# East West Rail Phase 2

### Stage 2 Road safety audit response report

### Offline Highways Passing Places – Package 2 – Oxfordshire (A3 Marsh Gibbon – Compound Access)

**Document Number: 133735\_RW-EWR-XX-XX-RP-CH-000049**

Drawing Title
PASSING PLACE A3_P_5 GENERAL ARRANGEMENT

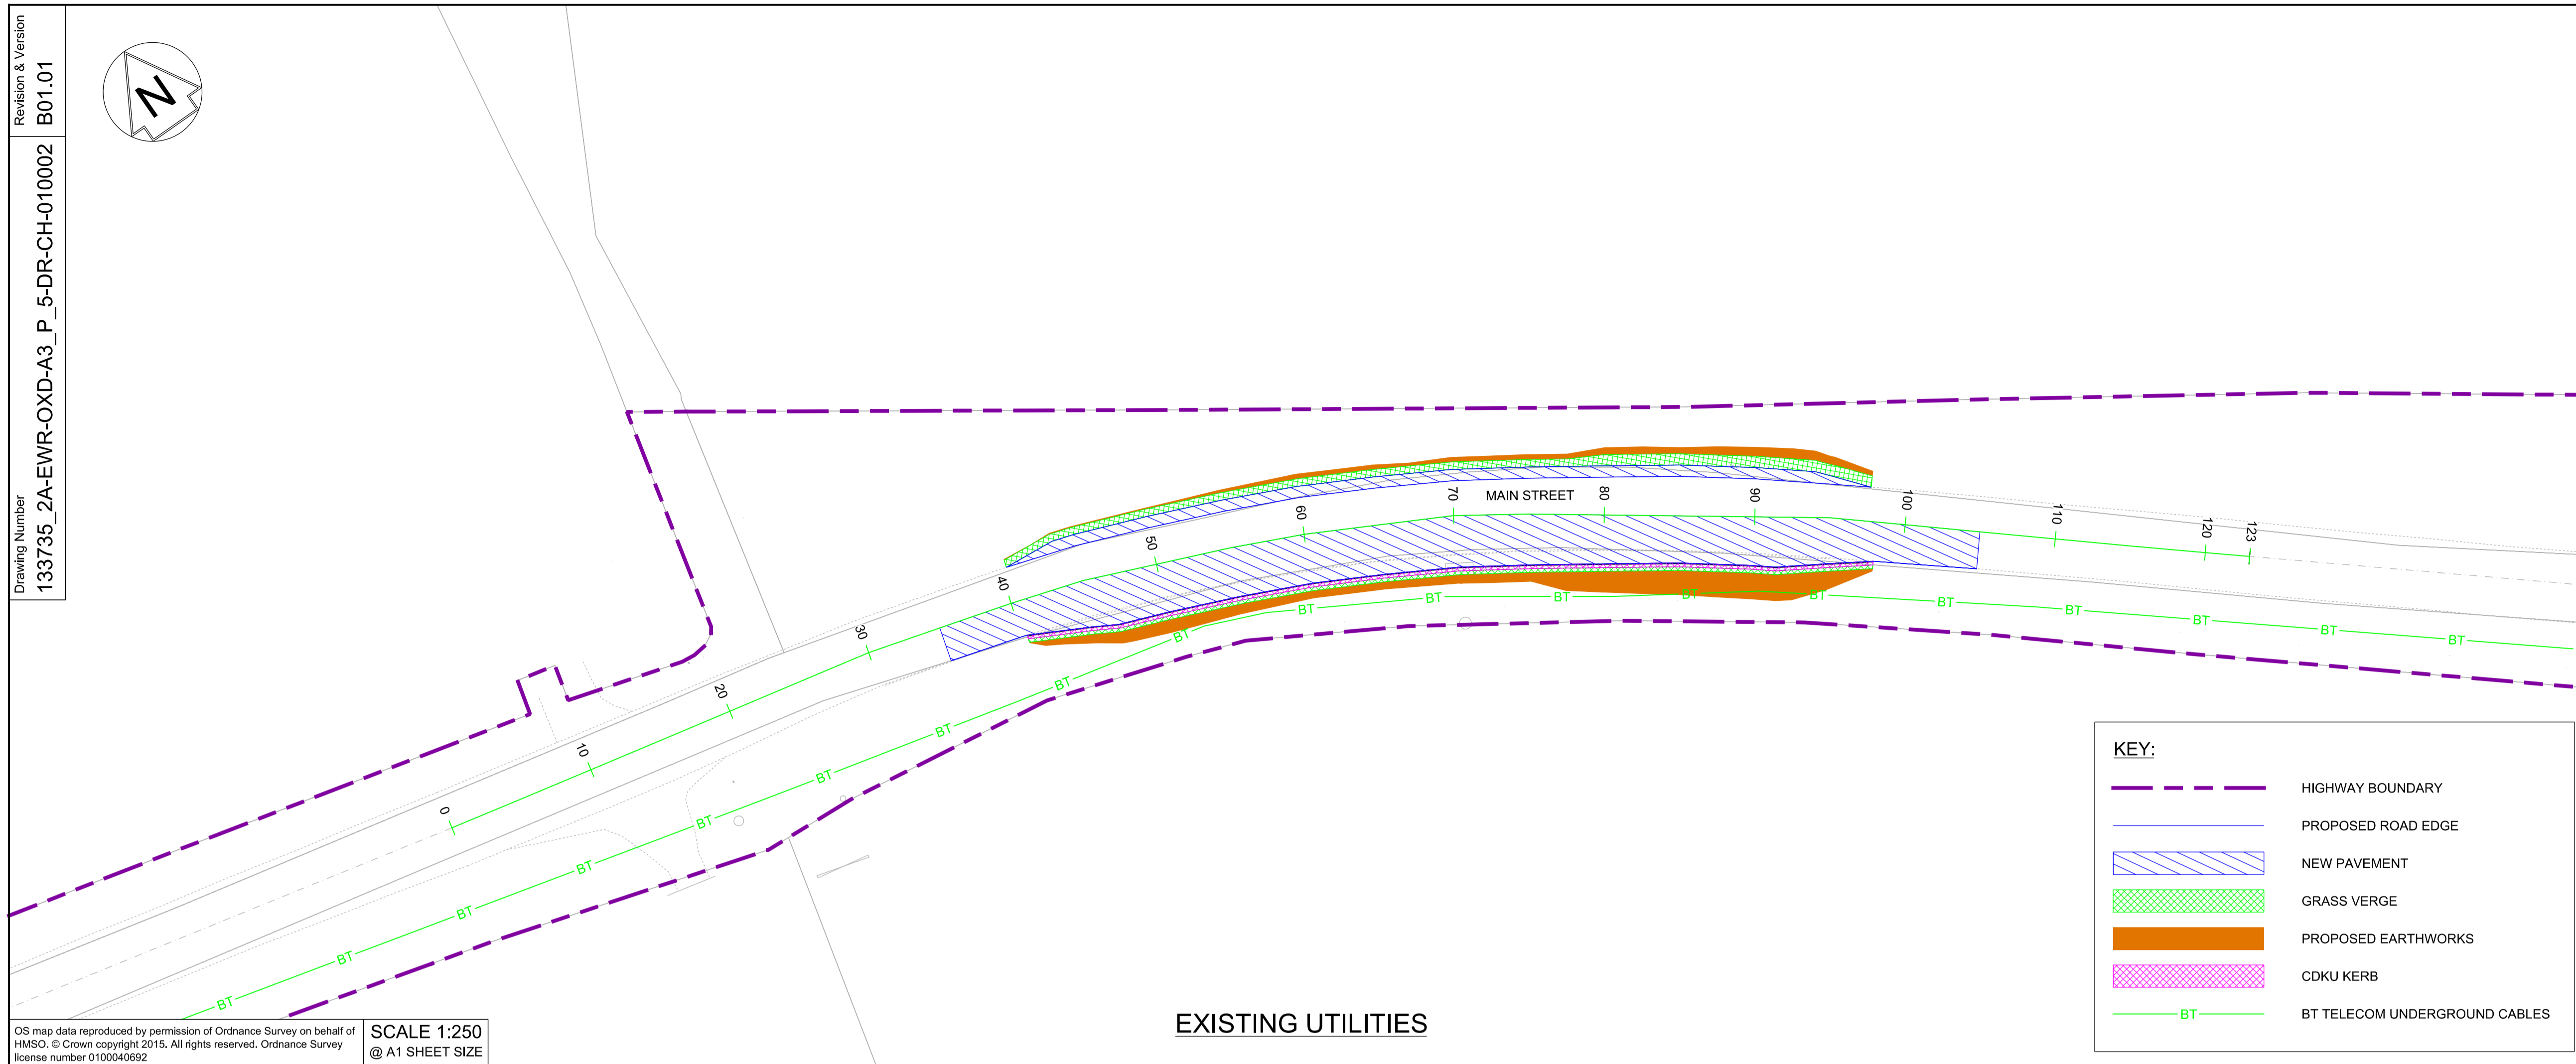
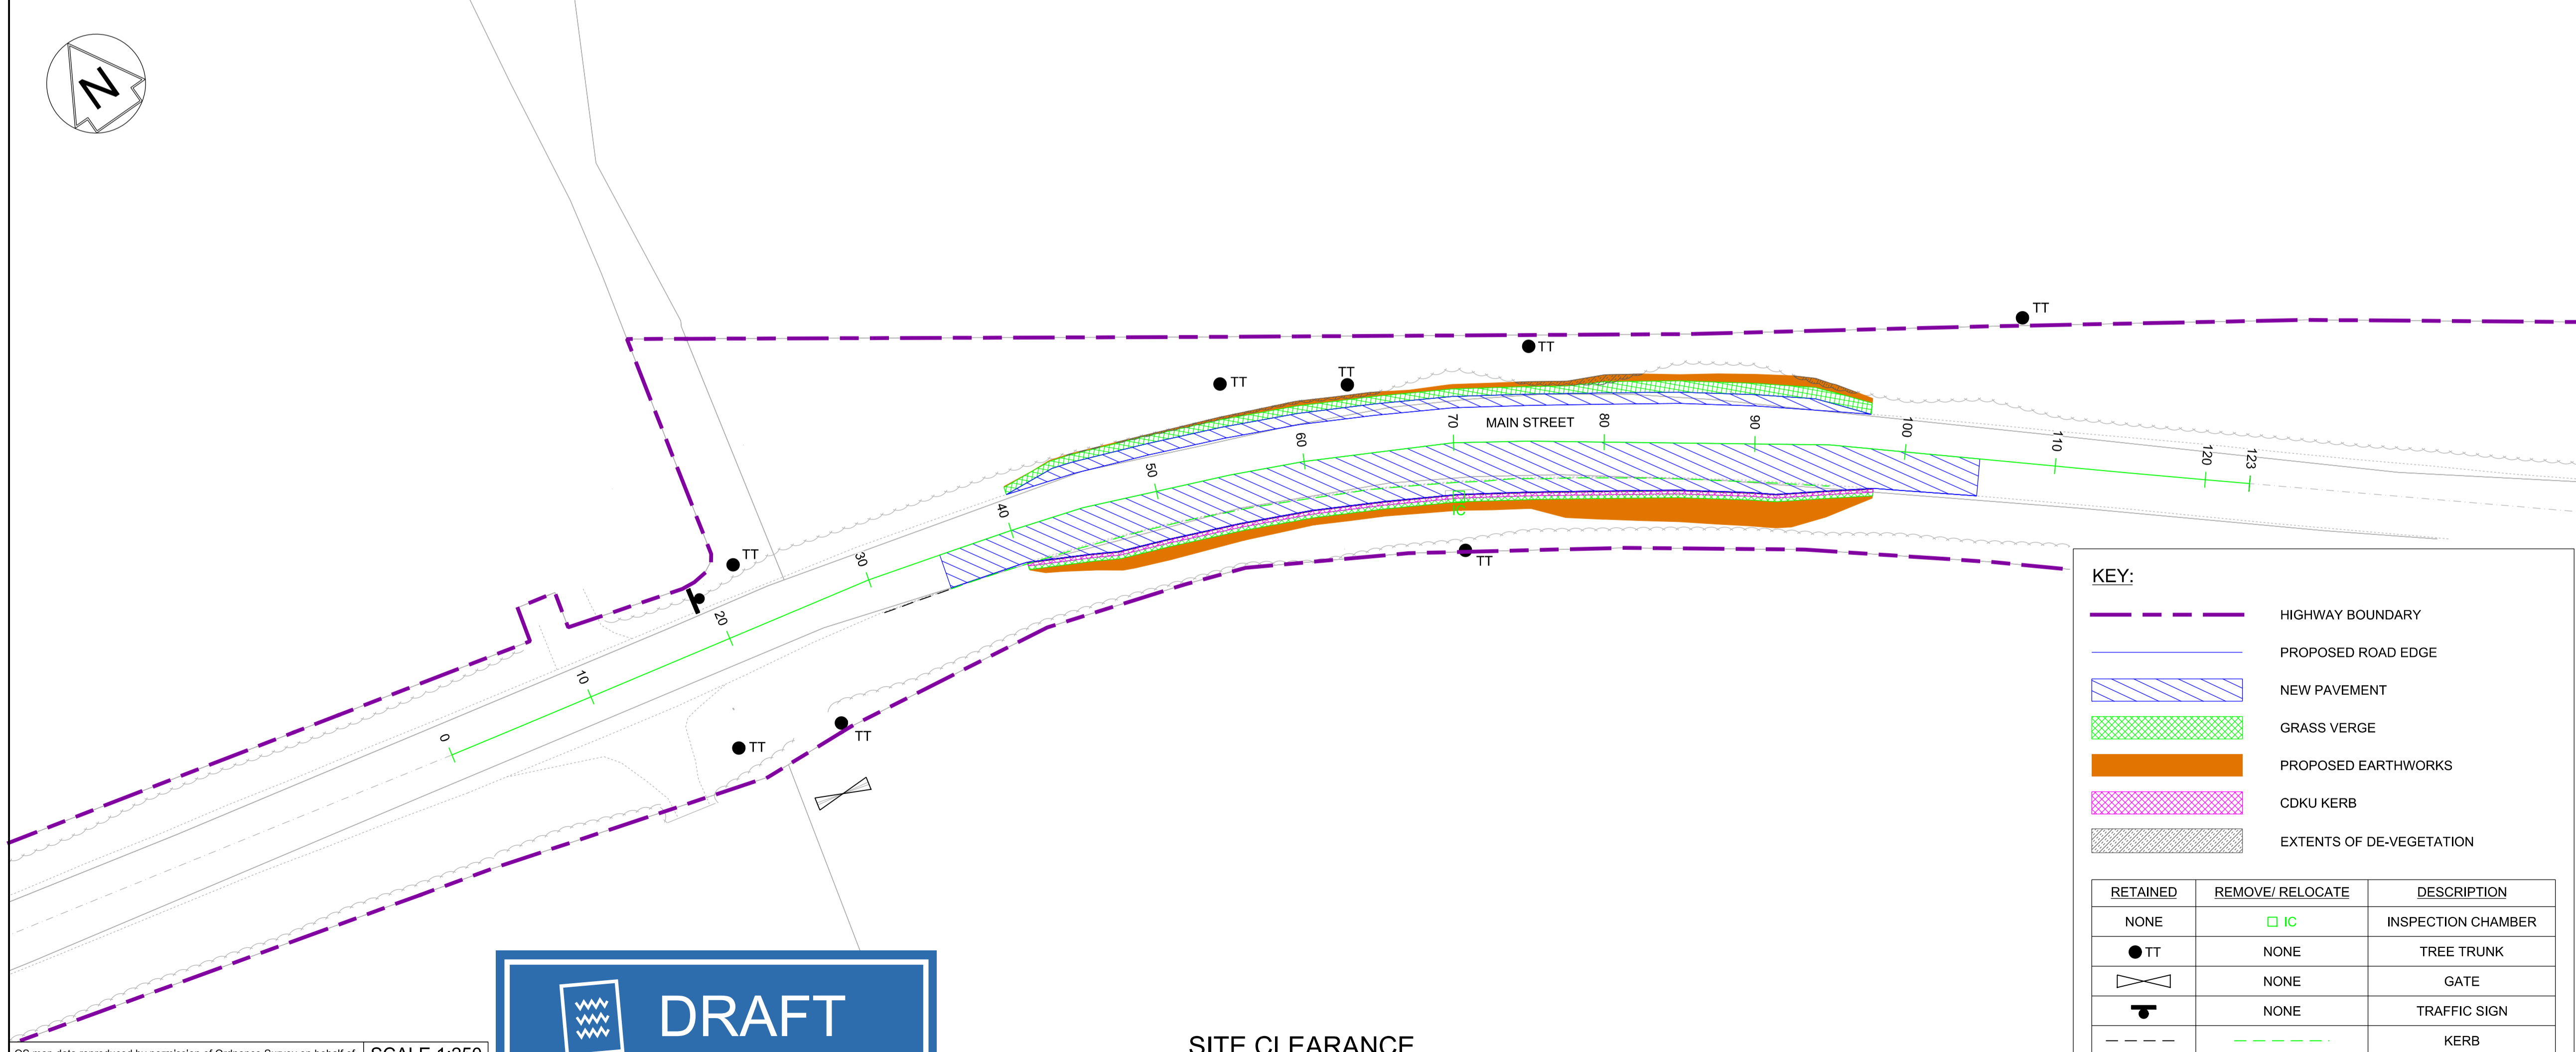
**A3-P-5, Unnamed Road (towards Mill Road)** – Provide traffic signing to warn pedestrians and construction vehicles of the passing place and presence of pedestrians, respectively. Trim back vegetation around the access to maximise visibility between pedestrians and drivers; or

Remove passing place A3-P-5 (eastbound) as passing place A3-P-6 is adjacent.

2.3	Passing Places A3-P-2, A3-P-5 and A3-P-9. Unnamed Road (towards Mill Road).	<b>Proximity of passing place to public footpath access increases risk of pedestrian being struck by vehicle</b> There are access to public footpaths directly from Unnamed Road (towards Mill Road) in the nearside verges just before the proposed passing places A3-P-2 and A3-P-5. The proposed location of passing place A3-P-9 is directly between the accesses to public footpaths on the north and south sides of Unnamed Road (towards Mill Road), with the passing place clashing with the access on the southern side. Due to the location of the passing places, there is an increased risk of a construction vehicle striking a pedestrian as they enter Unnamed Road (towards Mill Road), particularly as the construction vehicle will be preparing to enter the passing place. This issue is exacerbated by the lack of footway along Unnamed Road (towards Mill Road) as there is no segregation between vehicles and pedestrians.	A3-P-2, Unnamed Road (towards Mill Road) – Move passing place further downstream of public footpath access and provide traffic signing to warn pedestrians and construction vehicles of the passing place and presence of pedestrians, respectively. Trim back vegetation around the access to maximise visibility between pedestrians and drivers	<b>Accept the RSA problem raised but suggest an alternative solution.</b> Passing place to remain in proposed position in accordance with TWA0. Traffic signing to warn vehicles of the presence of pedestrians in advance of the public right of way interface shall be provided, on the northbound approach and before A3-P-2 and on the southbound approach and before A3-P-2. The site clearance drawings shall include vegetation clearance around the public right of way interface to maximise visibility for pedestrians and drivers. The RSA recommendations with respect to warning signage for pedestrians accessing the carriageway from a public right of way will be shared with the logistics team for inclusion.	Accepted	Proceed as Design Team Response

PASSING PLACE A3\_P\_8  
EXISTING UTILITIES AND  
SITE CLEARANCE

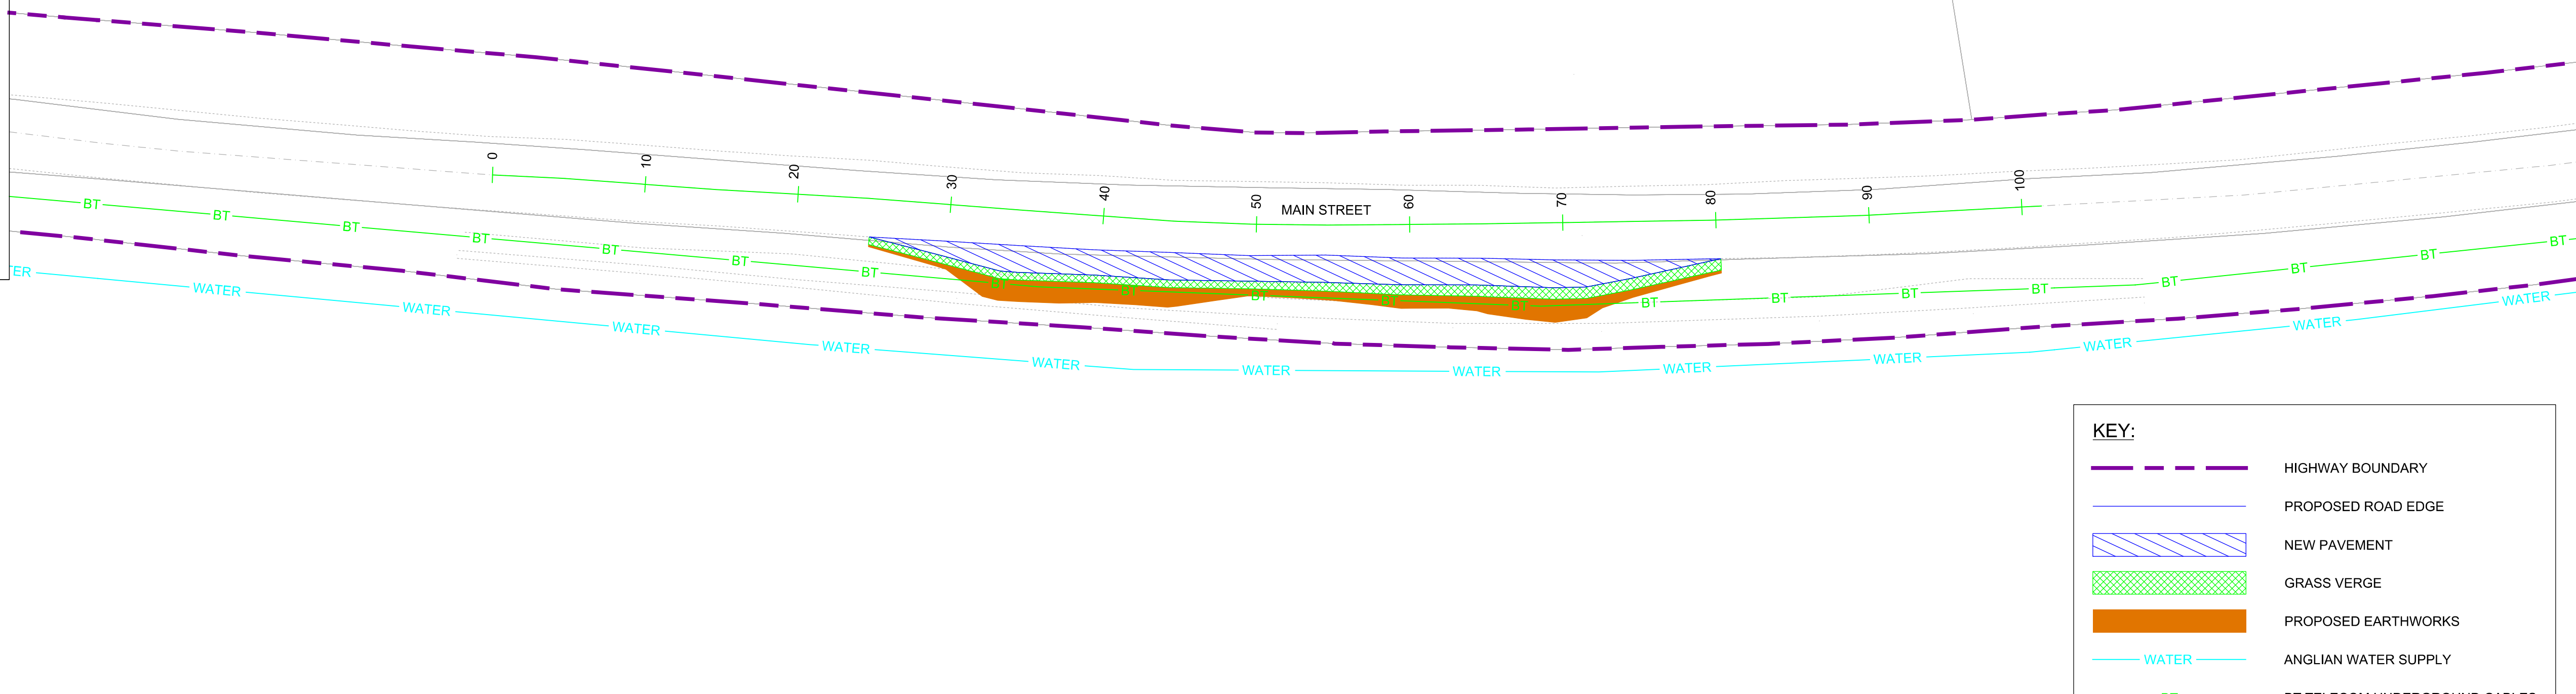
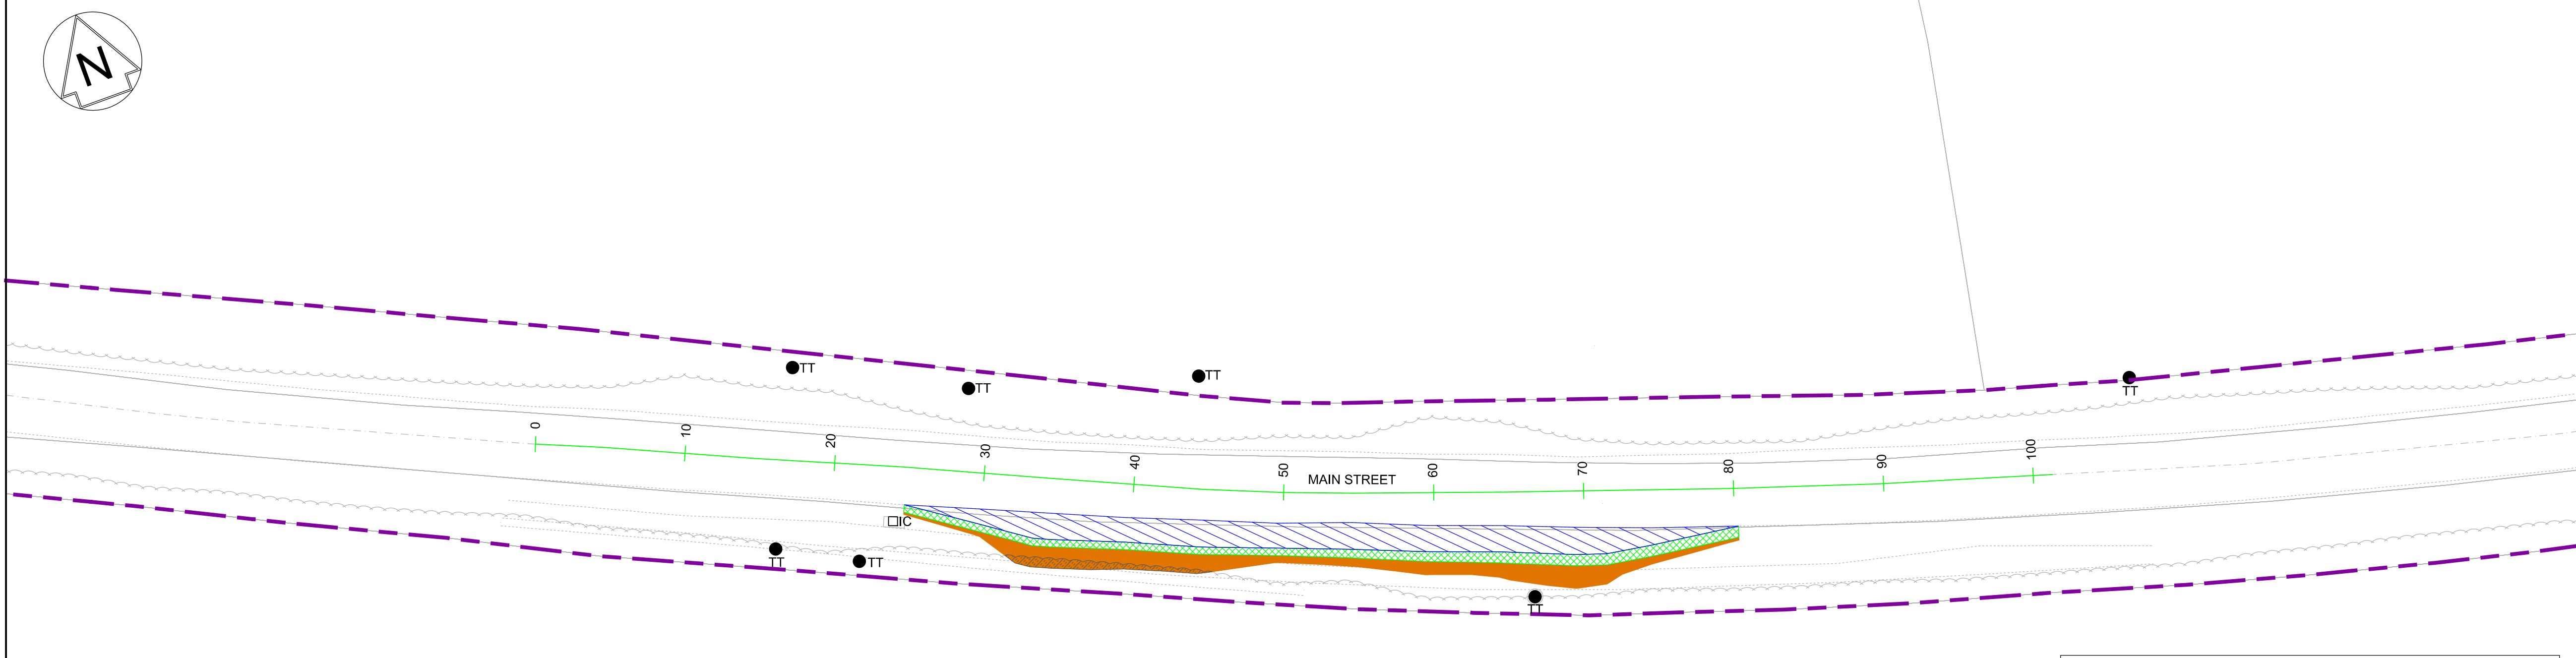
Driver accessibility to passing places is obstructed by trees, and in some locations, signposts situated in the verge. There is a risk that drivers may collide with the trees on entry/exit of the passing place. Also, drivers' forward visibility is restricted by the location of these trees and as such, drivers of construction vehicles may not be aware that they should wait and might proceed, increasing the risk of side swipe collisions. Additionally, approaching drivers may not anticipate the construction vehicle leaving the passing place, leading to side swipe or head on collisions.

Obstructions should be removed from the verges.

RSA Ref	Location	RSA Problem	RSA Recommendation	Design Team Response	Network Rail Response	Agreed RSA action
2.1	Passing Places A3-P-1, A2-P-1, A3-P-2 and A3-P-8. Unnamed Road (towards Mill Road).	<b>Obstructions in verge increase risk of collision</b> Driver accessibility to passing places is obstructed by trees, and in some locations, signposts situated in the verge. There is a risk that drivers may collide with the trees on entry/exit of the passing place. Also, drivers' forward visibility is restricted by the location of these trees and as such, drivers of construction vehicles may not be aware that they should wait and might proceed, increasing the risk of side swipe collisions. Additionally, approaching drivers may not anticipate the construction vehicle leaving the passing place, leading to side swipe or head on collisions.	Obstructions should be removed from the verges.	<b>Accept the RSA problem and recommendation made by the RSA team.</b> The site clearance drawings note that vegetation clearance shall be undertaken to provide suitable visibility. There is also a note for the lifting of tree crowns to provide 5m clearance above ground level to the back of the proposed verge.	Accepted	Proceed as Design Team Response
